Diane Sarkies - Re NSWL EIS 2

Infrastructure Projects Re Application No SSI-5414

Reference NWRL Proposal EIS 2

Figure 6.12 Cherrybrook Station - Indicative vehicle and pedestrian movements

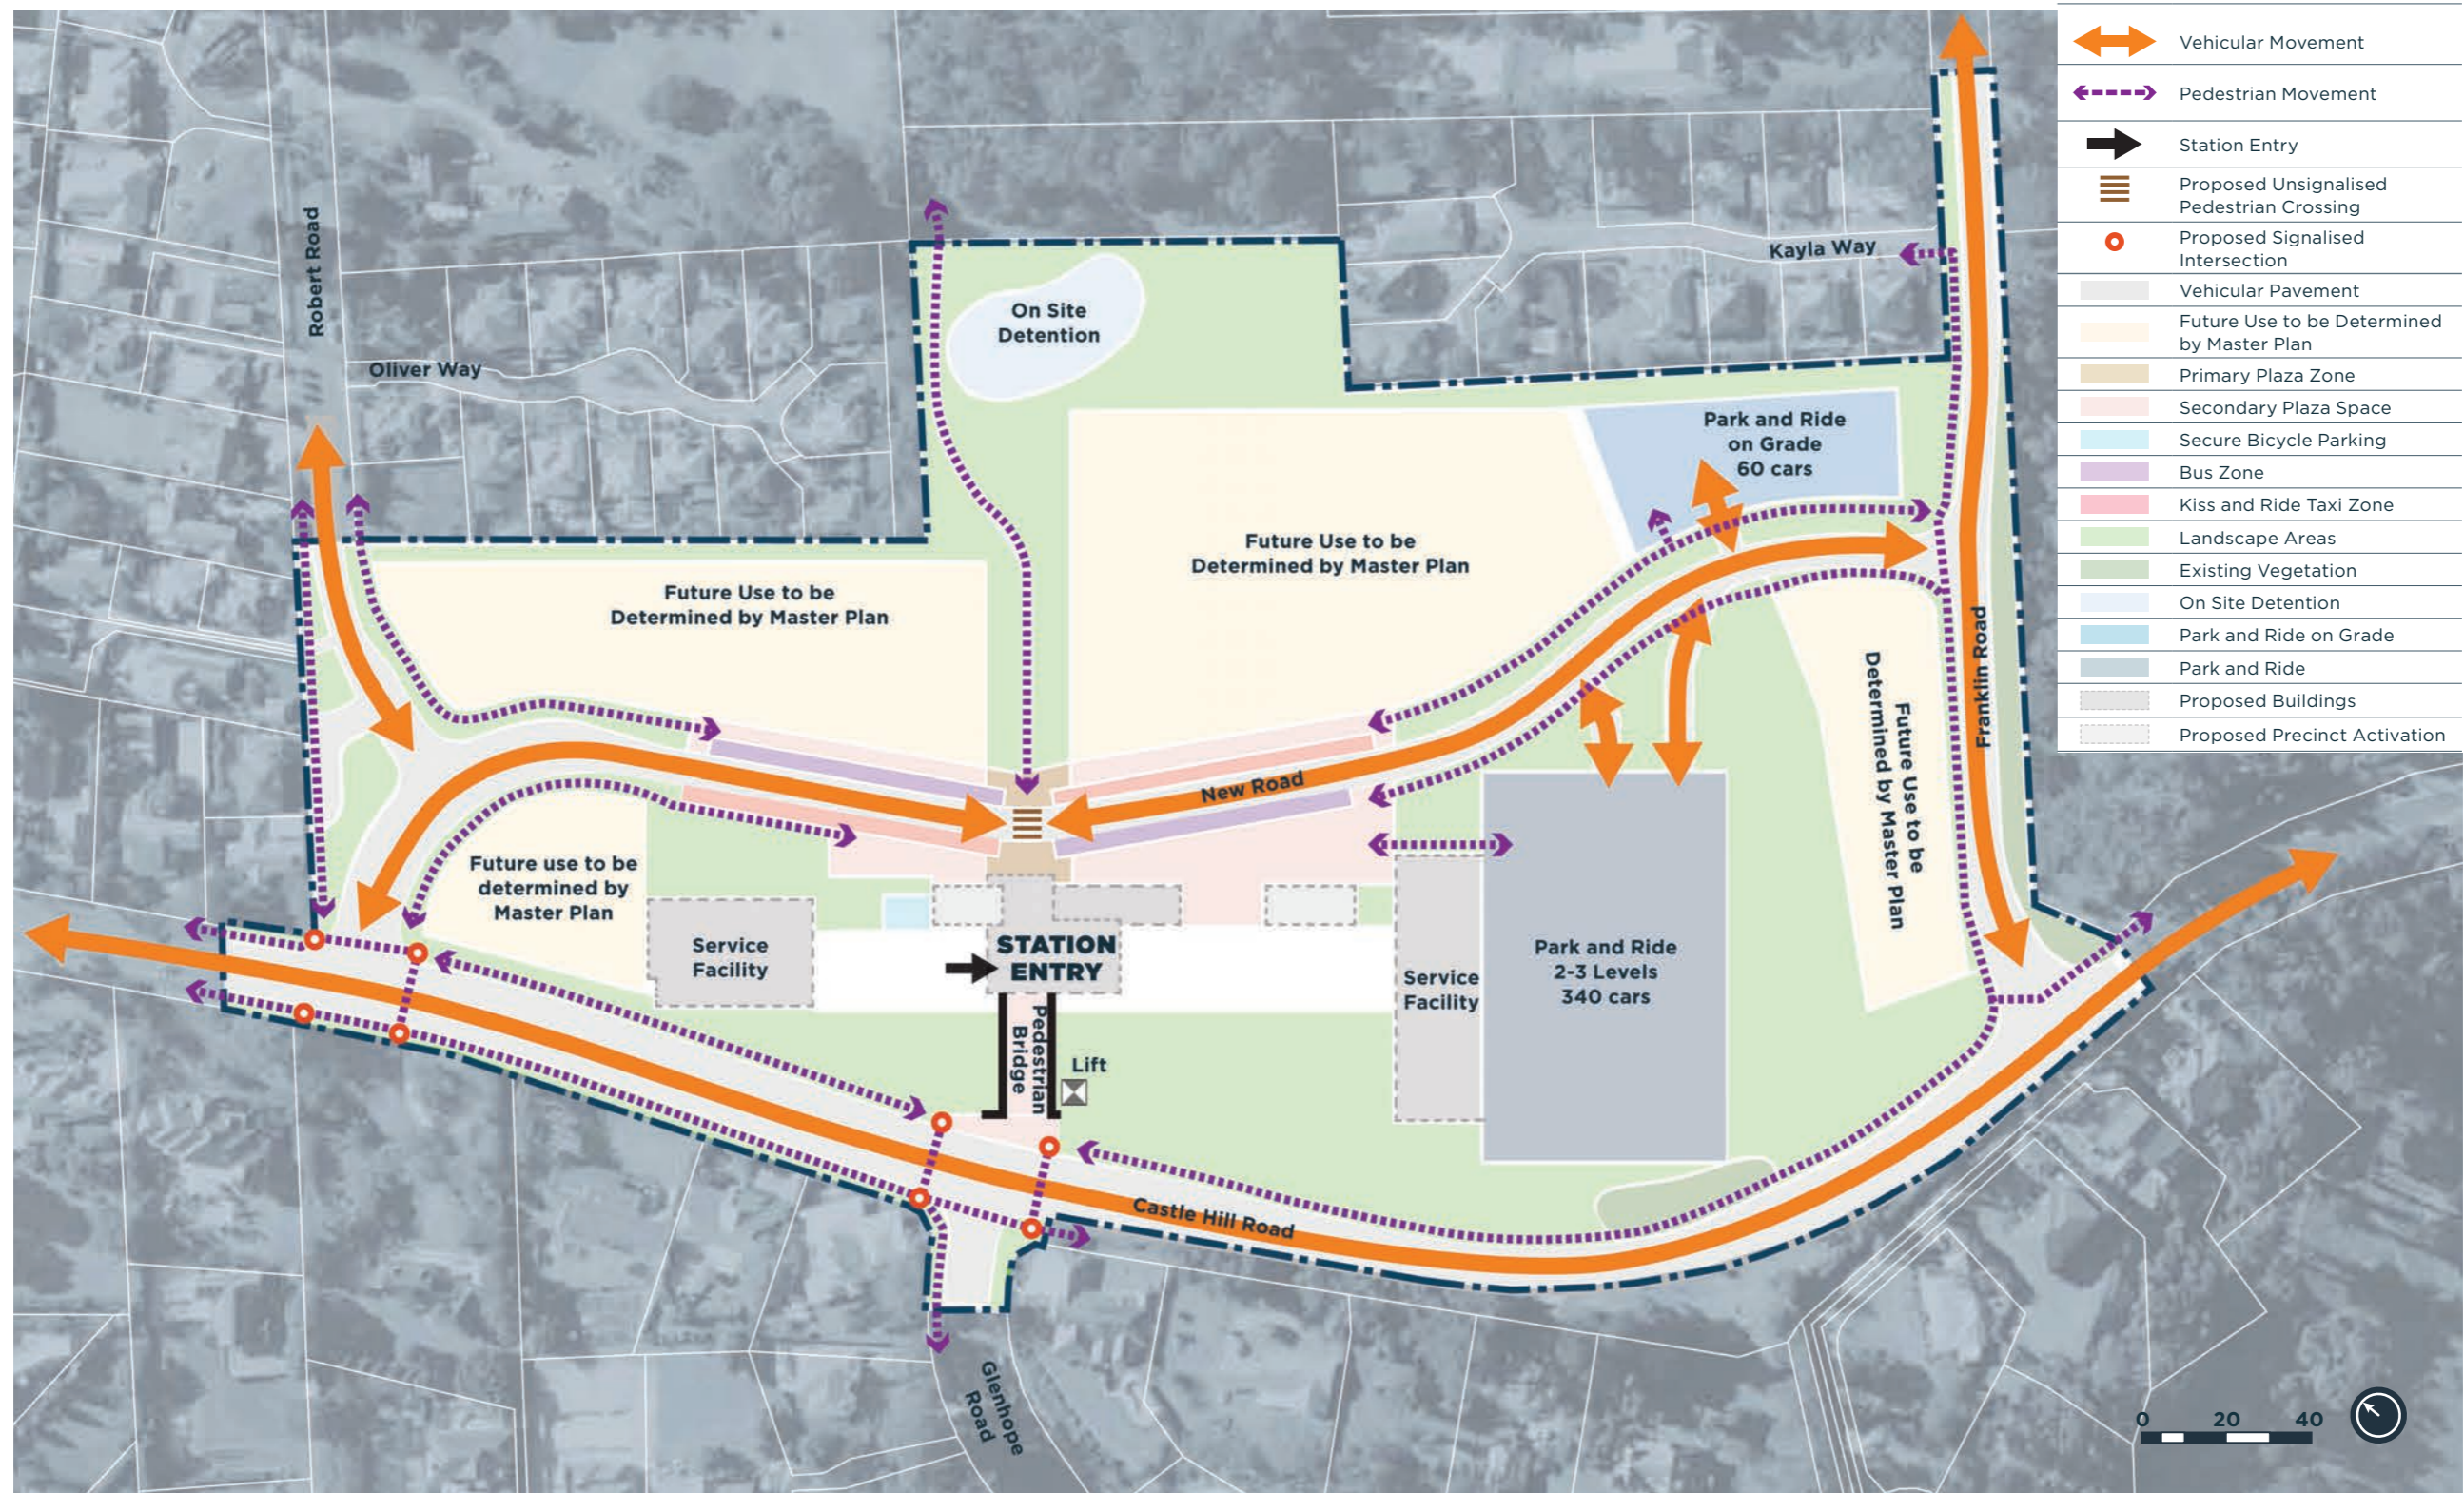
As a resident of Arundel Way Cherrybrook an estate that runs off Robert Rd ,I have some major concerns that the plan is to use Robert Rd as an "access road" to the Cherrybrook Railway Station.The reason for my concern is that Robert Rd in its present state is not wide enough to allow buses to run in both directions to the station as well as cars.I am also concerned that there will be no street parking in Robert Rd,our estate which consists of 30 homes & the estate has limited parking & it will make it very difficult for family & friends to visit residents in Arundel Way.It will also make it very difficult for residents of Arundel Way to exit & enter the estate.

The other concern that i have is that on the corner of Robert Rd & Dalkeith Rd there is a park called Robert Park & in this park is a childrens playground which during the day is used by parents with young children.If the plan to use Robert Rd as an access rd goes ahead with the volume of the expected traffic & with there being no parking in Robert Rd parents will not be able to use the park & its facilities.I also feel that with the volume of traffic expected it could endanger childrens lives.

In my opinion the best solution for the access to the station would be via County Drive,this would avoid the traffic being gridlocked in peak hour.
